119-B-2
115 Longfellow St.
Duplex
Gary Smith

May 21, 2001

RE: 115 Longfellow Street
(CBL#119-B-002)

The Planning Department has received your application for the construction of a residential duplex at 115 Longfellow Street. After review of the submitted plans and materials, the following comments have been generated:

1 FRONT ELEVATION  
1/4" = 1'-0"

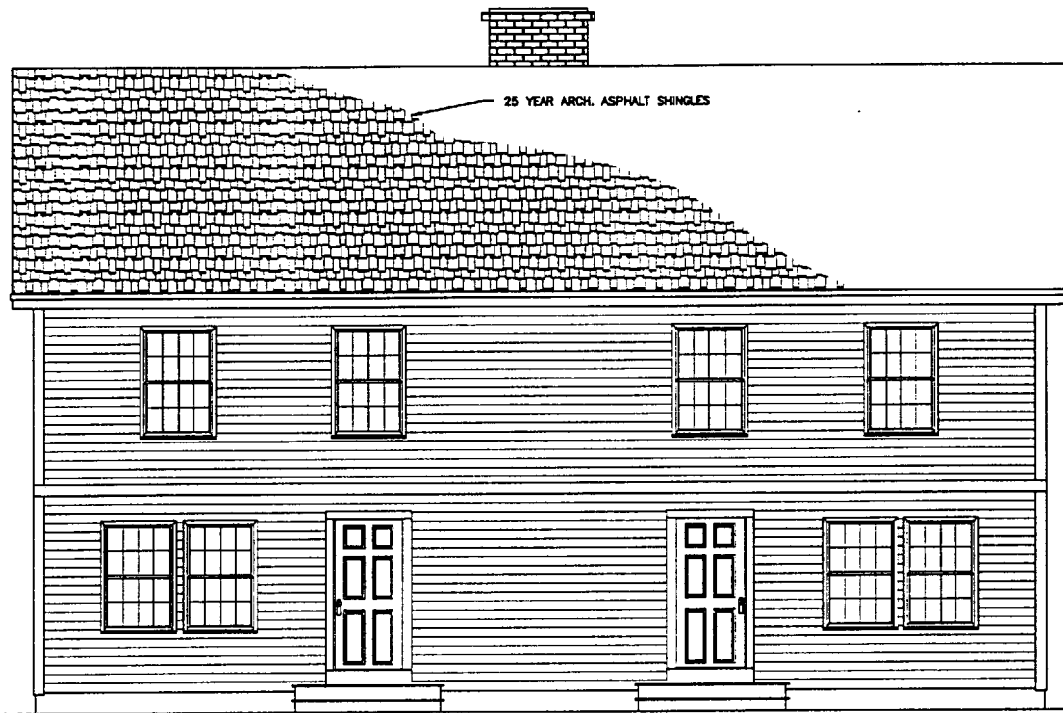
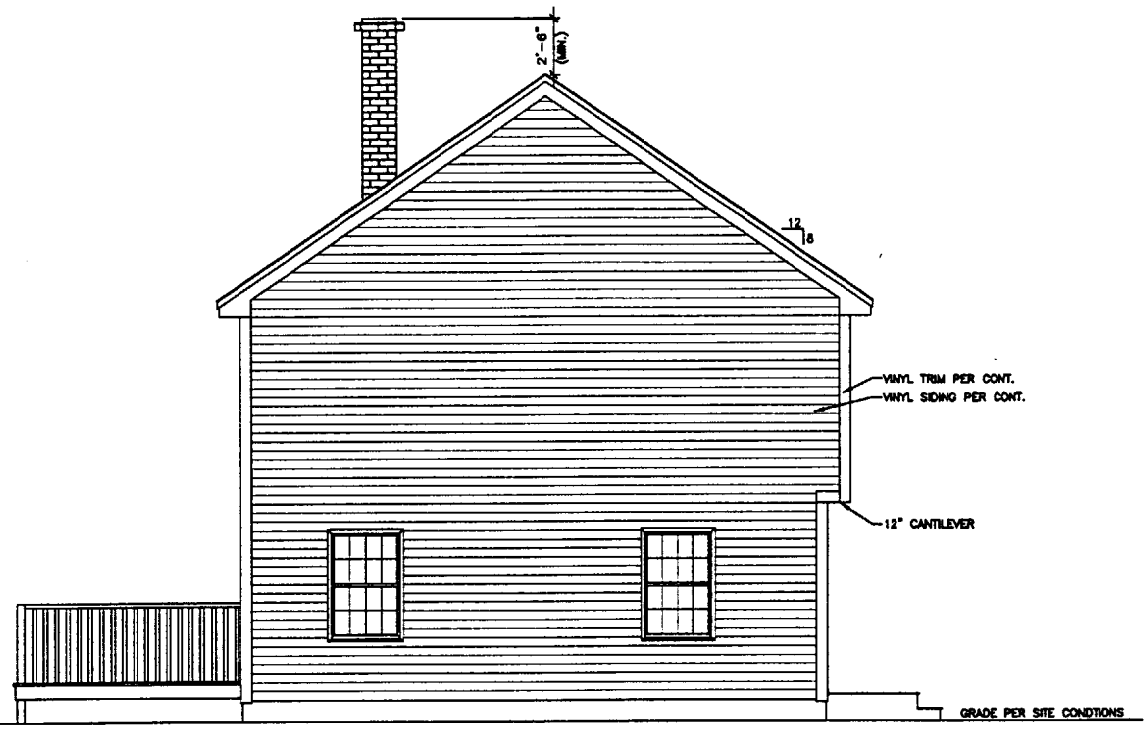
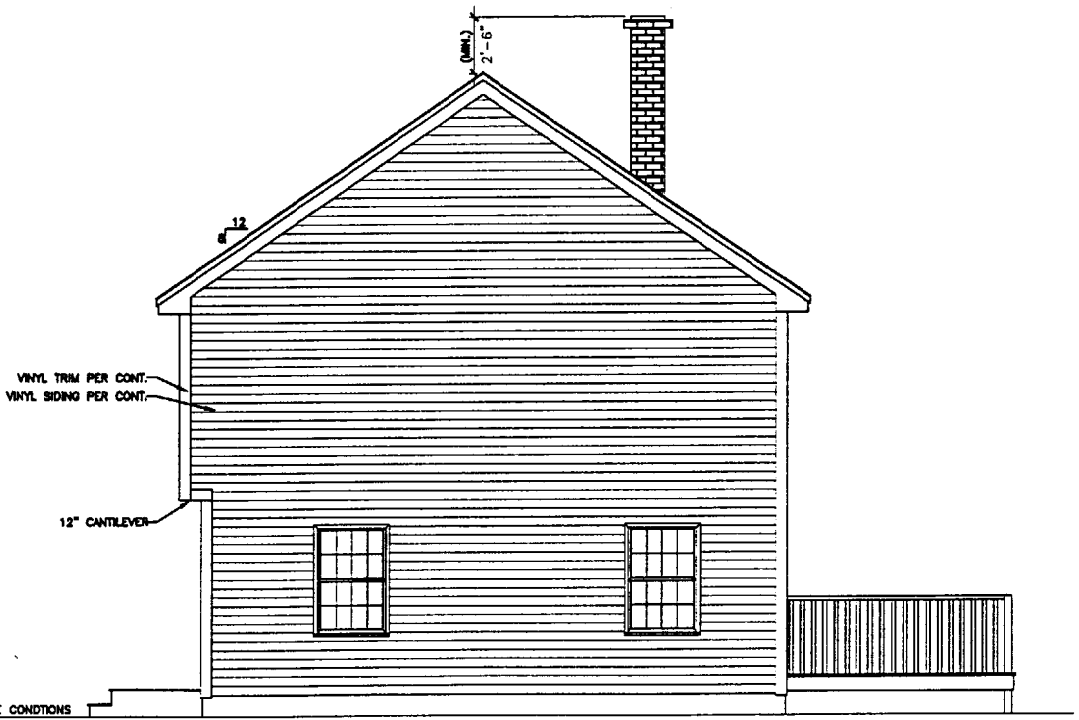
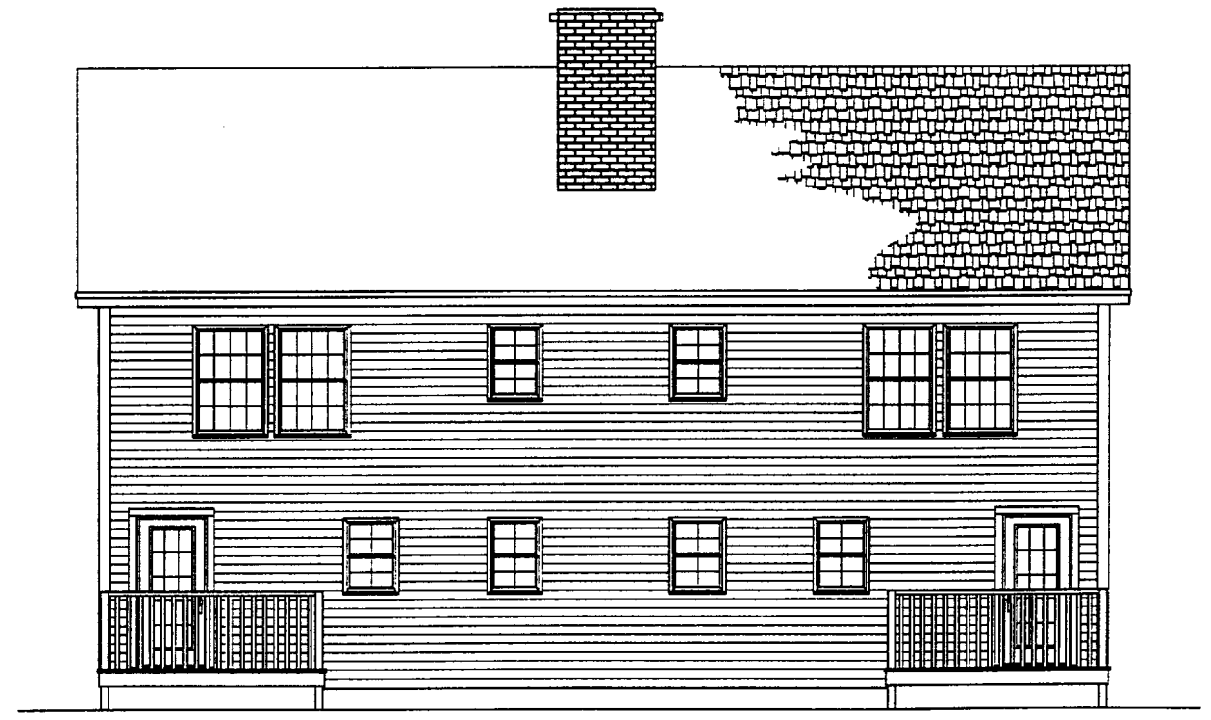
2. Standards require two windows per elevation, per floor where the floor plan will accommodate such placement. Additional windows to be located in the second floor bedrooms are required.
